June 14, 2010

Re: 349 Stevens Avenue – 122 F002 – R-5 – illegal deck

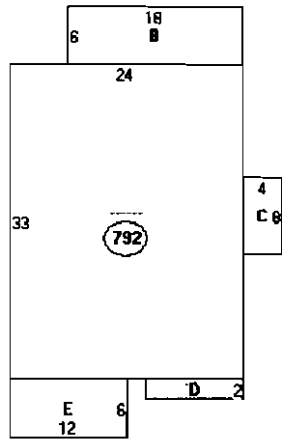
349 Stevens Avenue is located in the R-5 residential zone. Section 14-120(d)(3)(a) gives the minimum side yard setback for a one story structure as eight feet. The submitted plot plan gives the side yard setback to the deck as four feet. Section 14- 425 allows for a one story entrance porch to encroach into a setback as long as it does not extend more than six feet off the principal structure and the total square footage of the porch does not exceed fifty square feet. The existing deck is more than fifty square feet.

You need to bring your property into compliance. The deck either needs to meet the eight foot side setback or meet the criteria of section 14-425. You have thirty days from the date of this letter to make the deck legal.
